WILPSHIRE PARISH COUNCIL

26 July 2012

GT 3/2012/0555 proposed rear extension at 22 Vicarage Lane Wilpshire

Proposed Rear Extension at - 22 Vicarage Lane, Wilpshire. for - Mr. P Iddon.

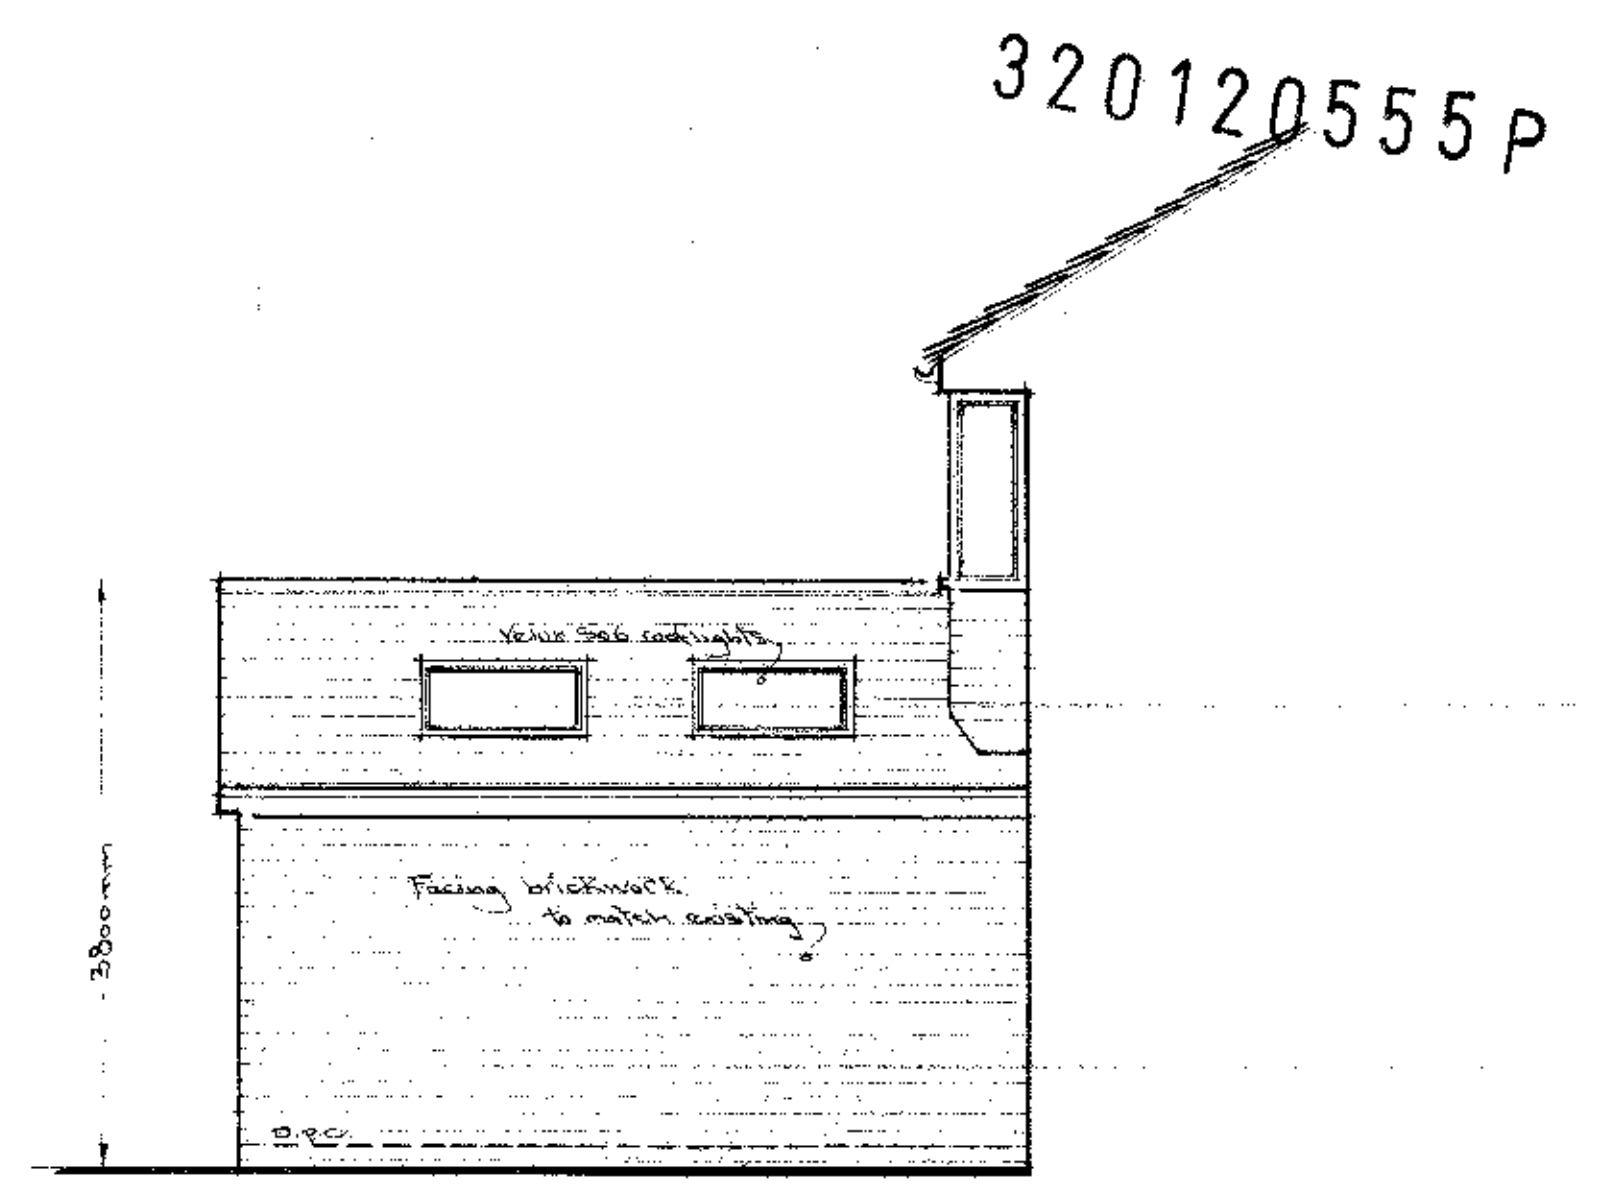
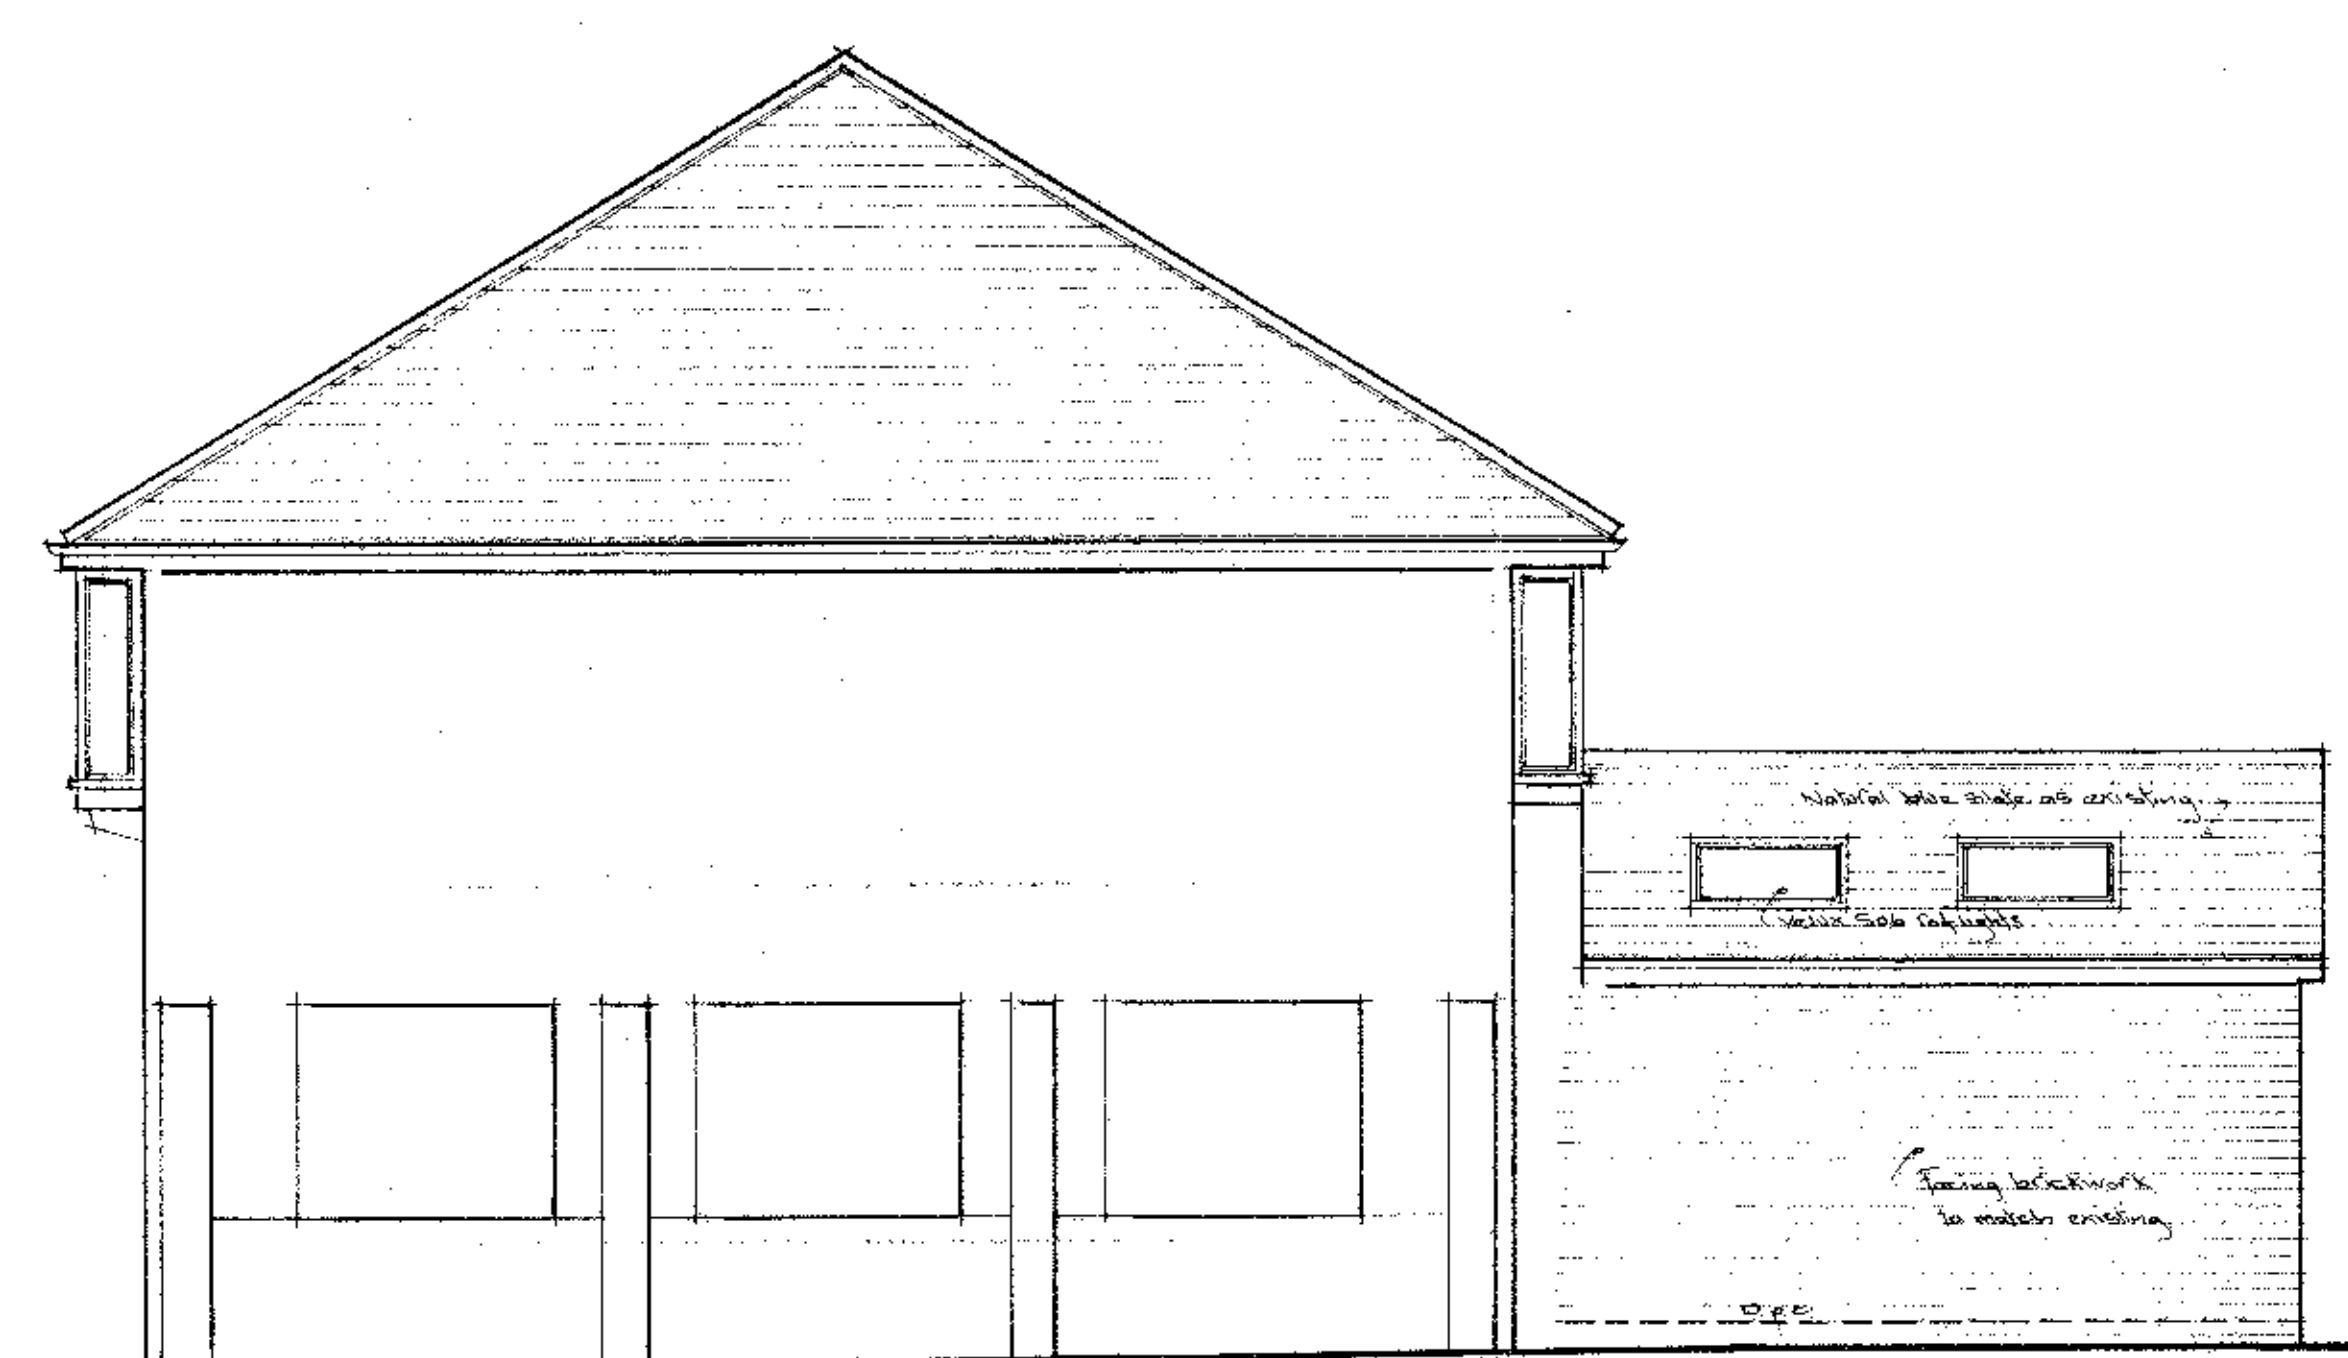
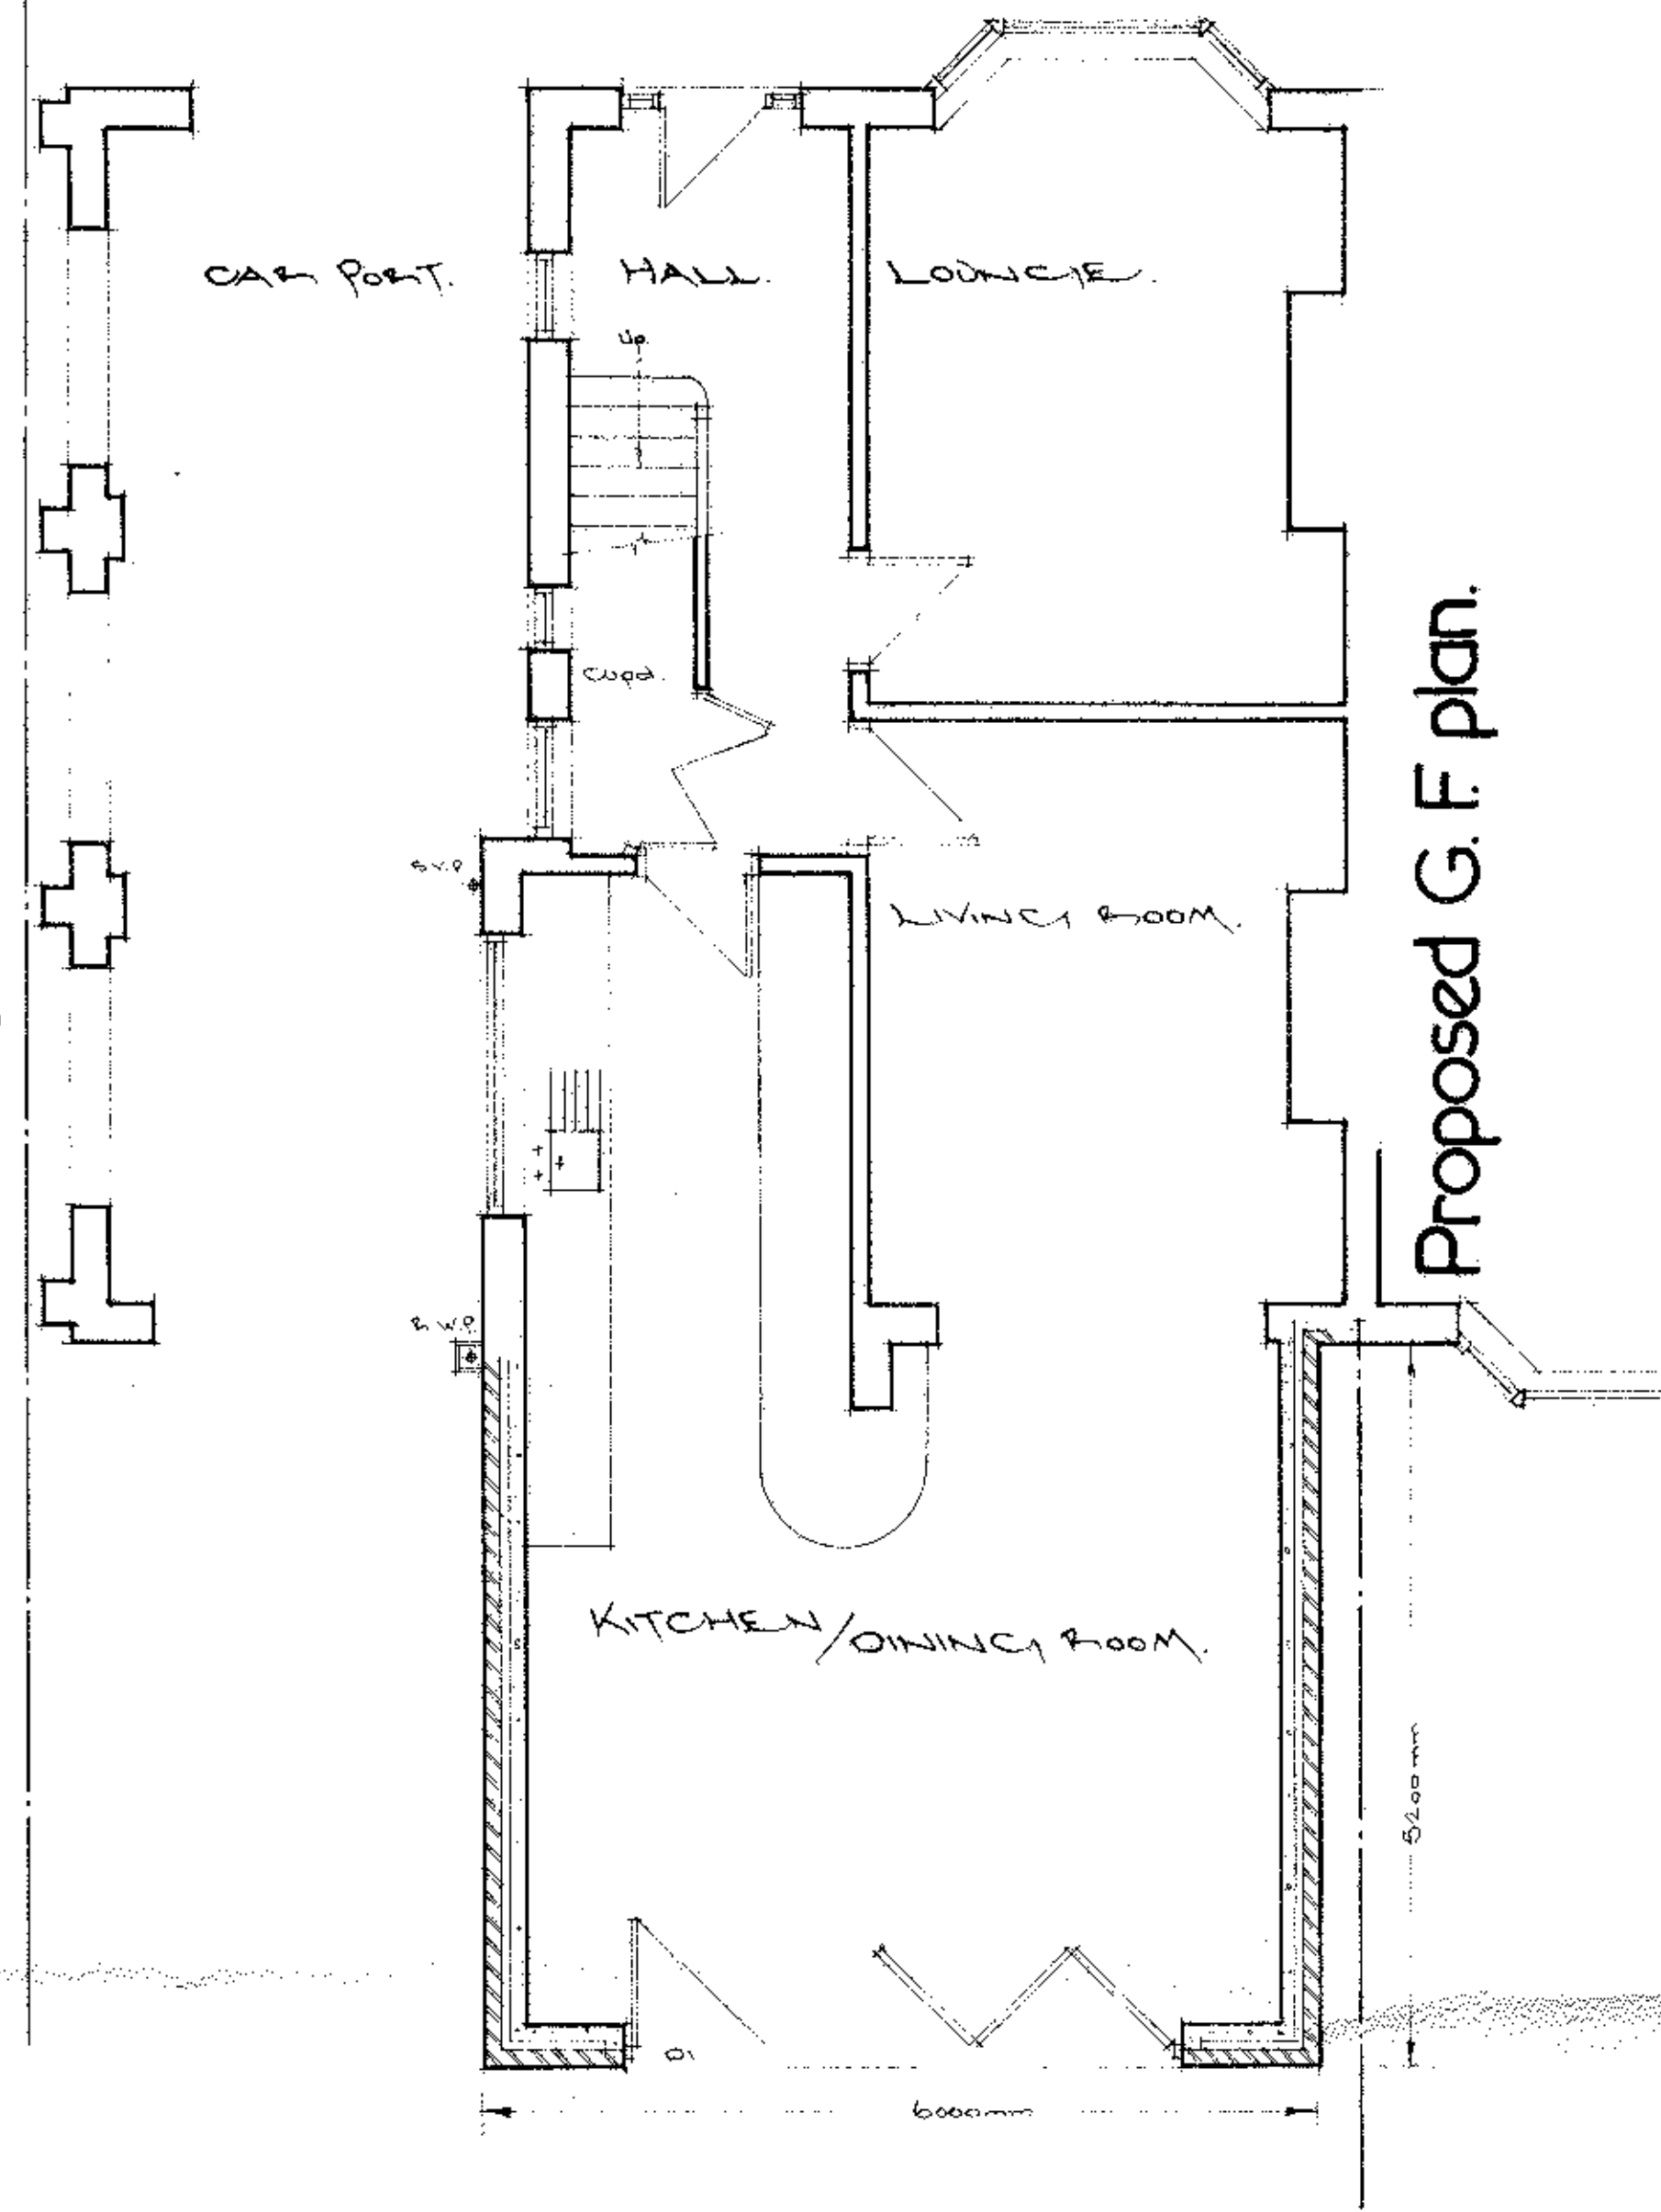
The parish council would comment that it believes that the proposed extension could take light away from the adjoining property.
